October 10, 2023

Subject: Sears Plat; Mercer Island, WA
Comment Response Letter

Thank you for your review of the Preliminary Short Subdivision and SEPA Review applications permit documents and your comments letter dated August 16, 2023. We at Navix Engineering have prepared comment responses below and hope you find the resolution of the review comments acceptable. Please feel free to contact me with any questions or coordination items you have.

SHEET NUMBER
C2.0

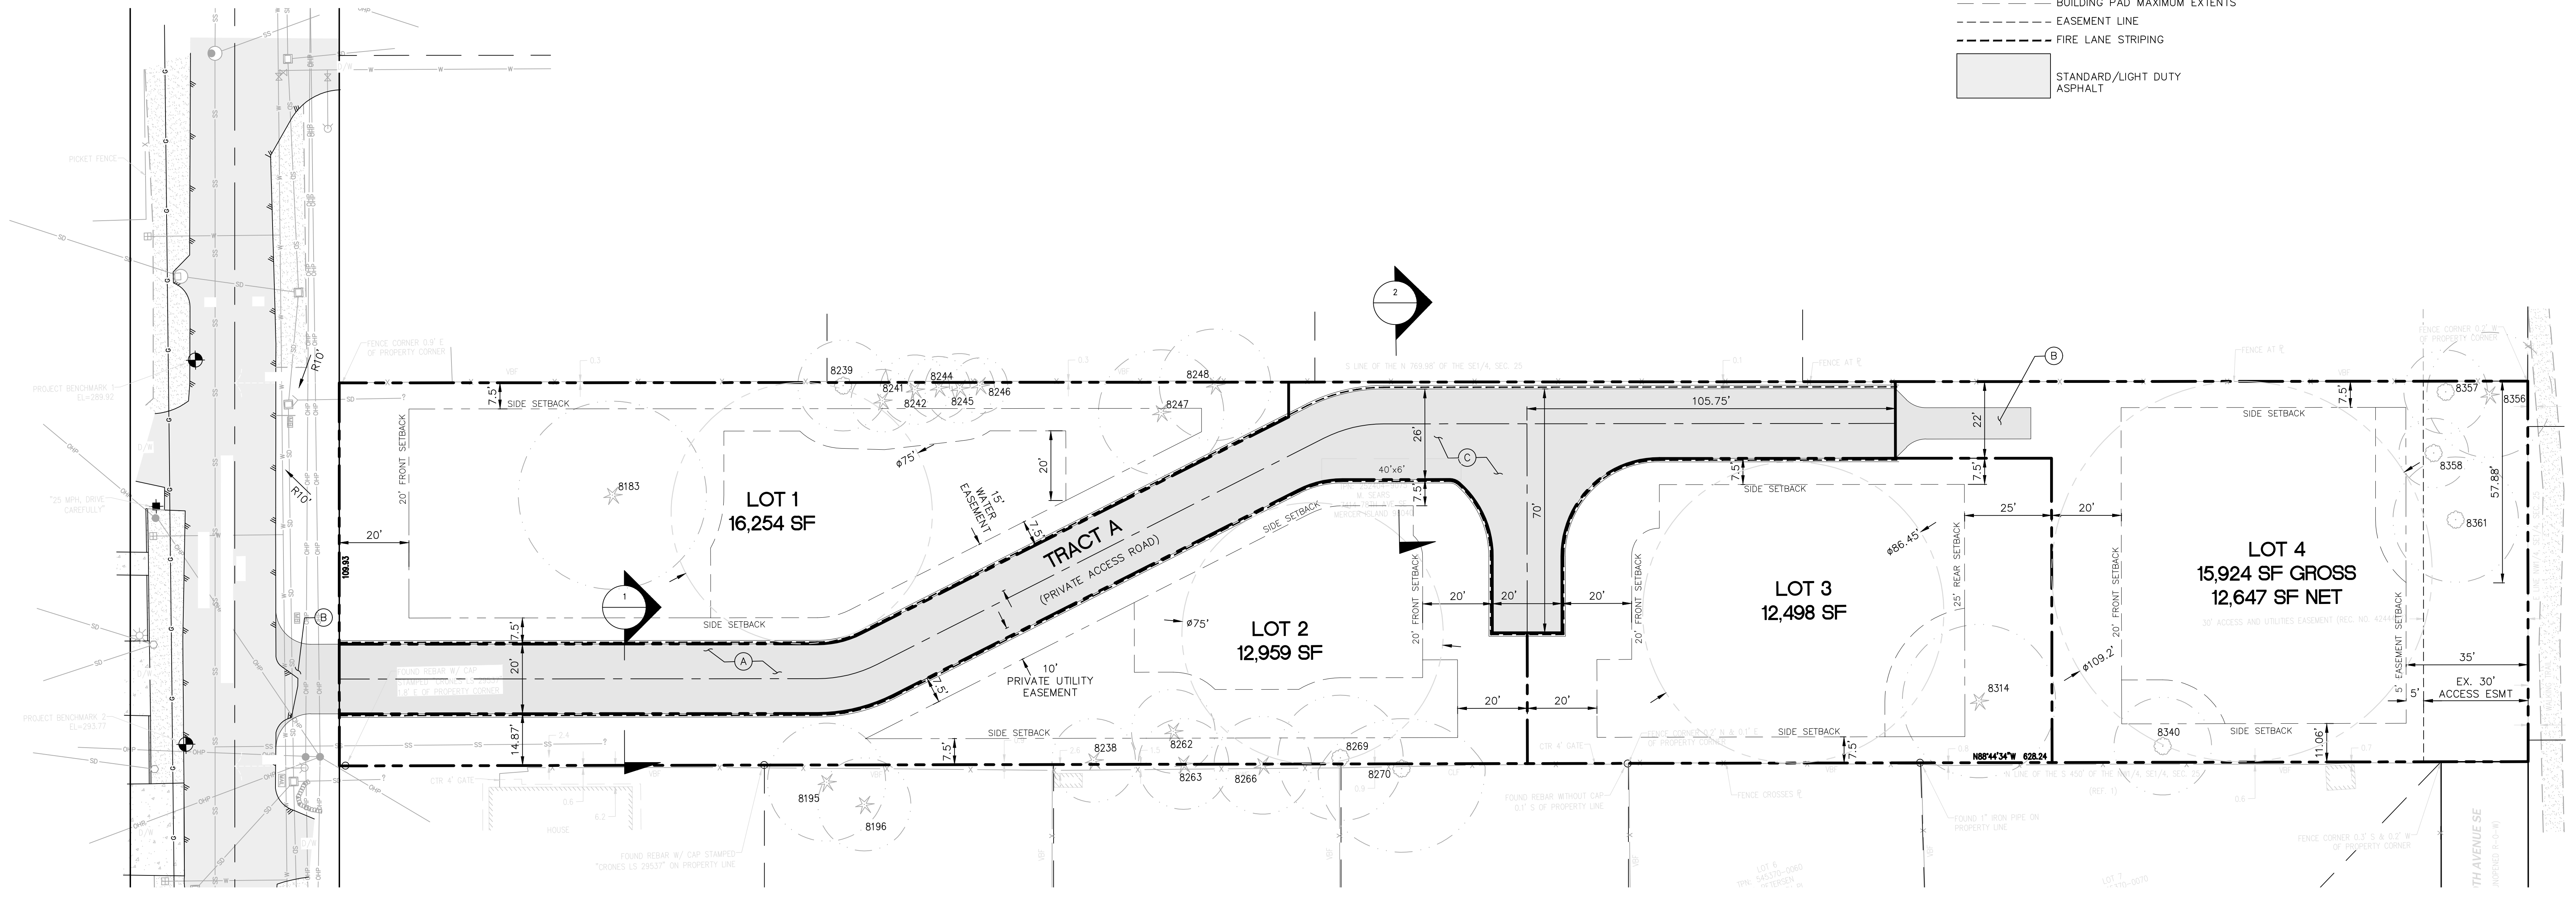
1. No Parking Fire Lane signs and/or paint curbs must be added to the access road. Please indicate the location of the signs or markings on the plans.

Response: No Parking/Fire Lane markings have been added to the plans. See sheet C2.0.

4. MICC 19.09.090(A)(1)(a) requires that building pads shall be located to minimize the removal of trees and impacts to trees and vegetation required for retention. Please revise the building pads to account for impacts to trees and vegetation.

Response: Building Pad Limit lines have been added to the civil plan set to show the area where the building pad could be located. See sheet C2.0.
